D2016/4188

**Proposed Warehouse and Logistics Hub 585-649 Mamre Road, Orchard Hills (Penrith LGA)
– SSD 7173**

Proposed road works

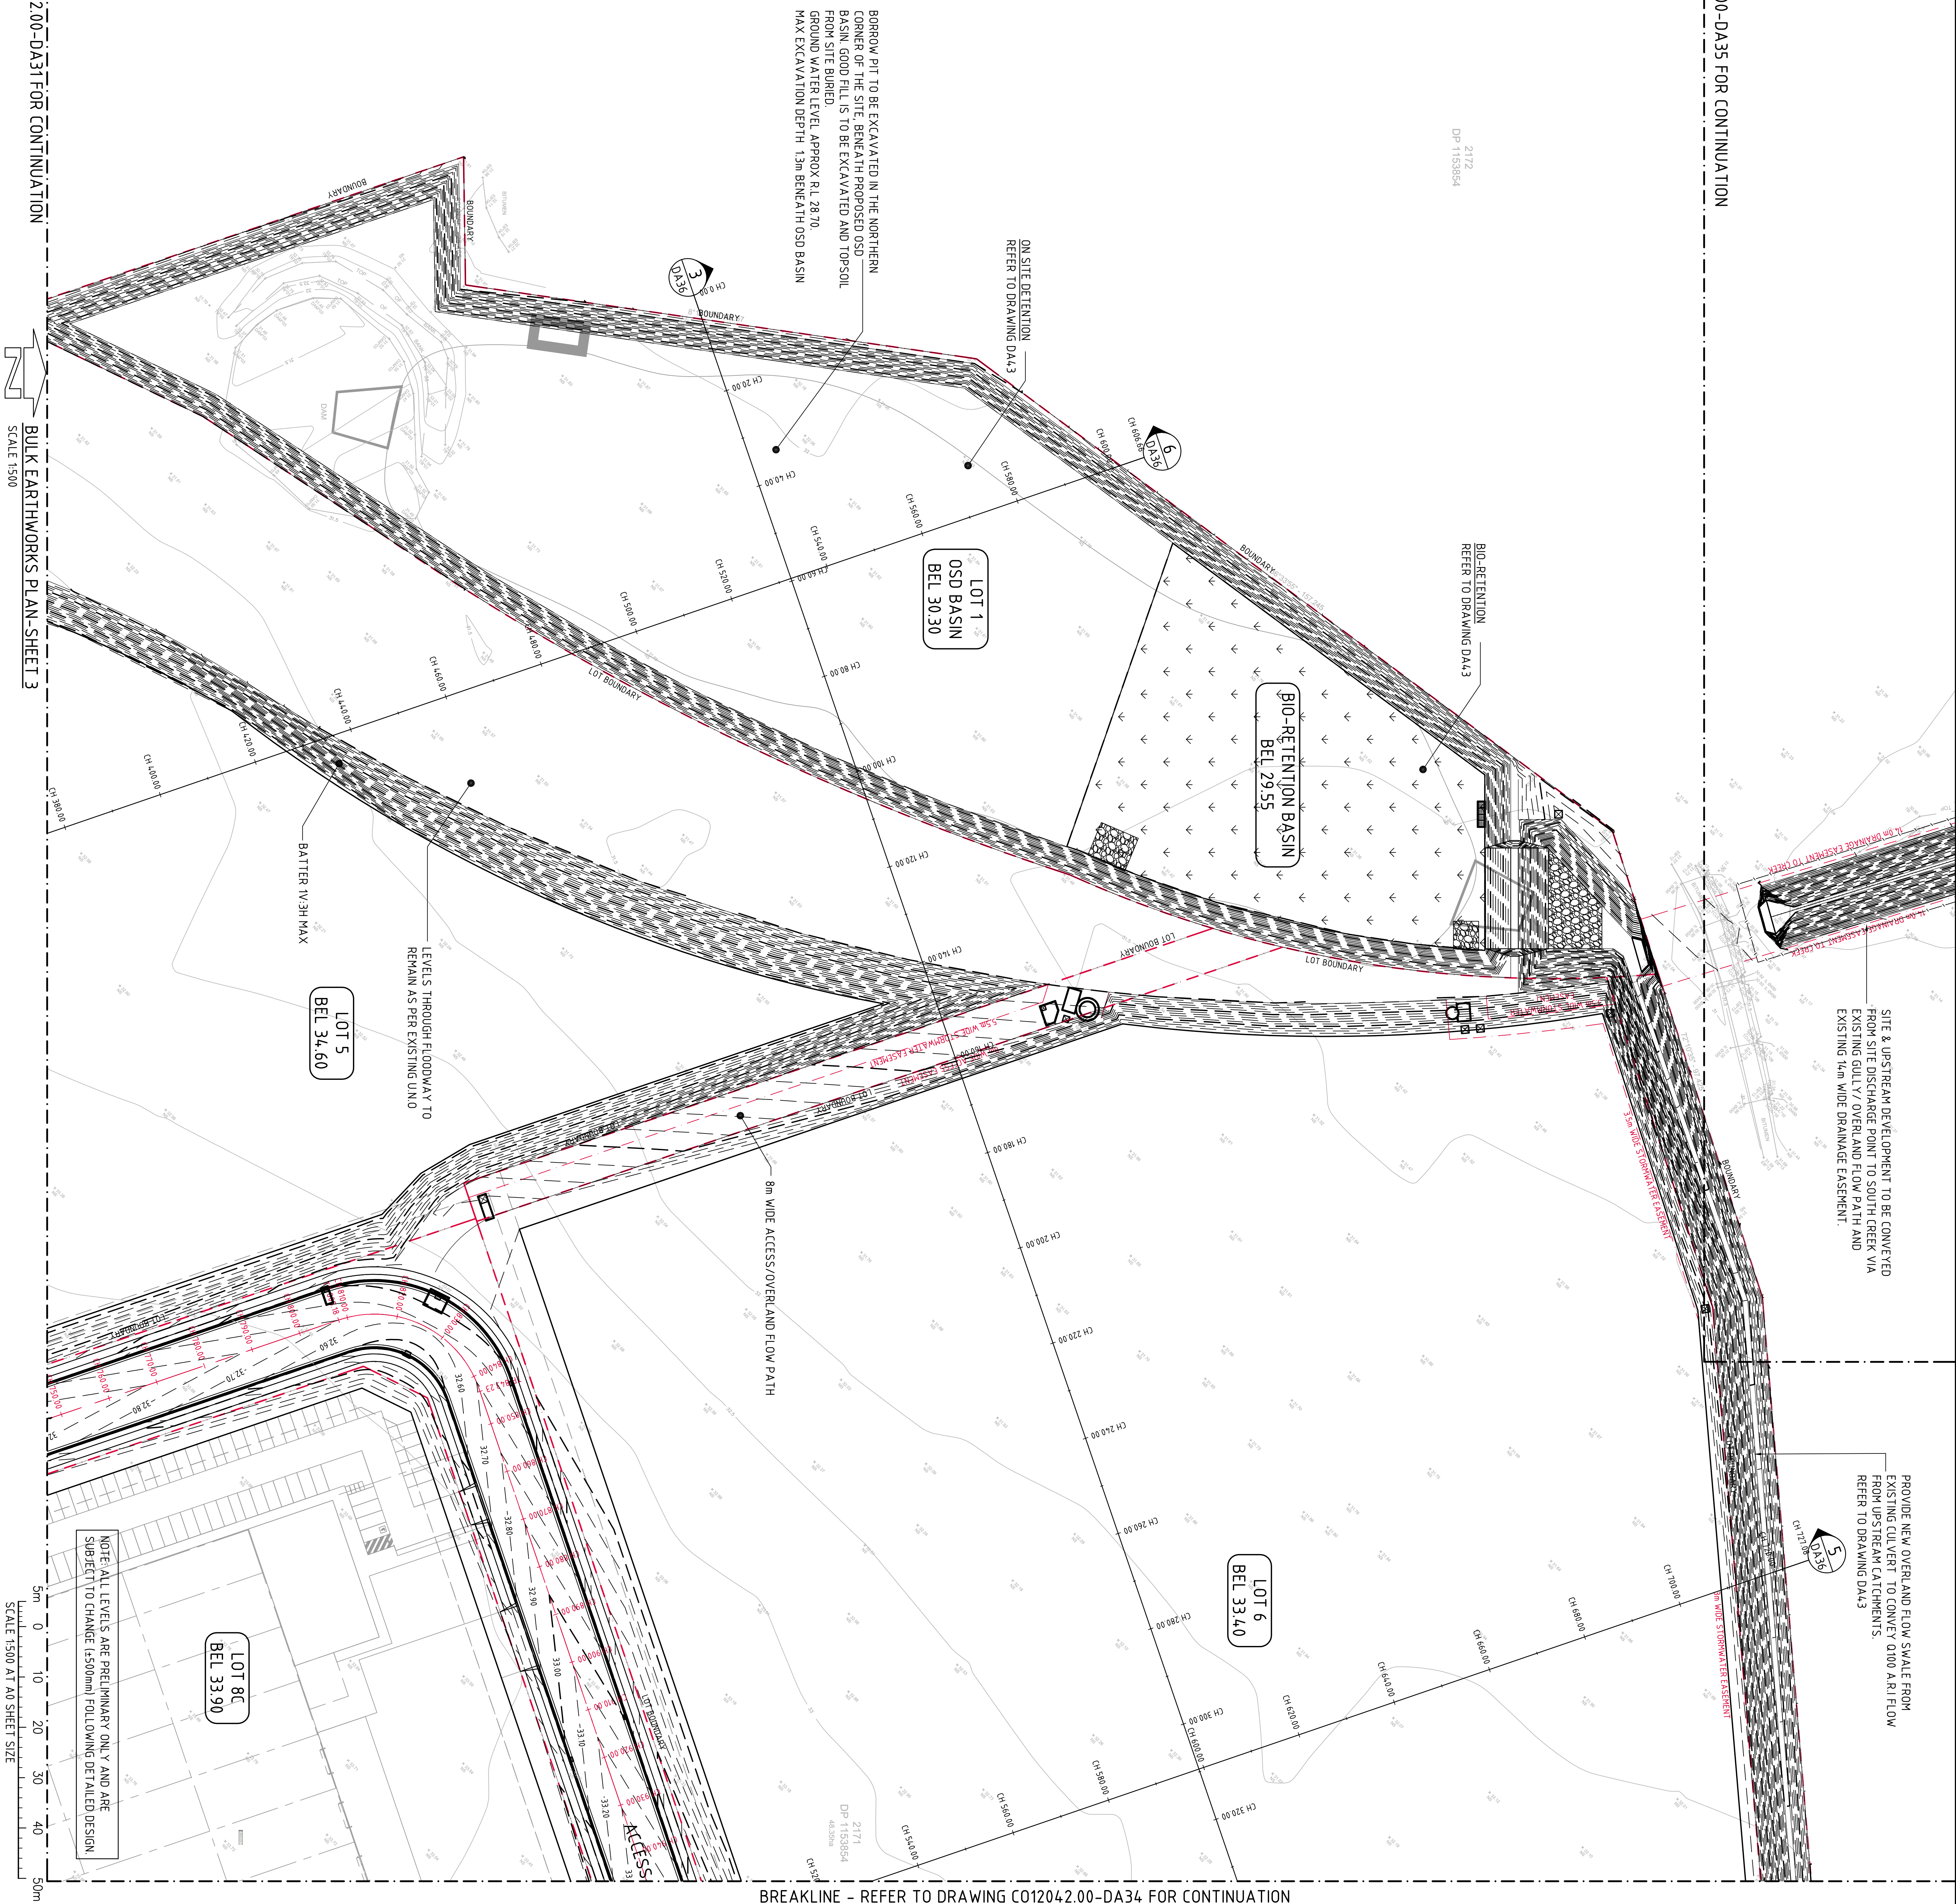
The southwestern corner of the proposed development described as Block 4 is shown in the bulk earthworks cut and fill plan (Drawing: C012042.00-DA30 Bulk Earthworks Cut/Fill Plan) as being subject to a borrow pit. WaterNSW notes that this area was originally excluded from development as a result of flood concerns, and is currently used to convey stormwater from the Pipeline corridor. WaterNSW requires that the flow of stormwater from the Pipeline corridor must not be impeded or caused to flow back to the corridor.

EROSION AND SEDIMENT CONTROL PLAN - SHEET 2
SCALE 1:500

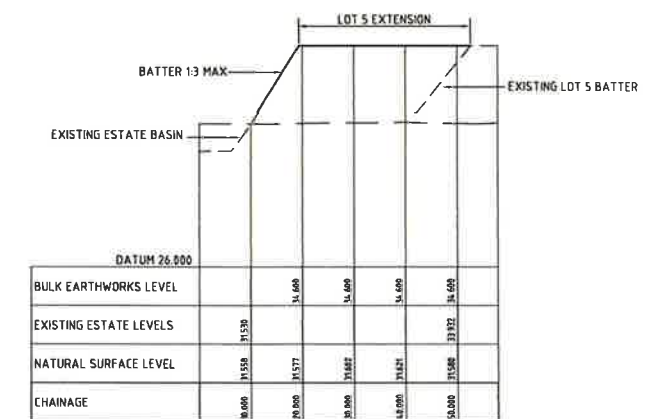
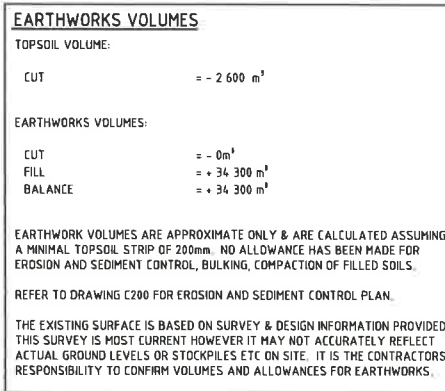
The erosion and sediment control plan for the proposed development contains no details of controls for the area of Block 4 noted in the EIS and the associated bulk earthworks cut and fill plan as a "borrow pit". To ensure there will be no impact to the Pipeline corridor during the construction phase, WaterNSW requires the EIS and the associated erosion and sediment control plans to be updated to reflect inclusion of these requirements.
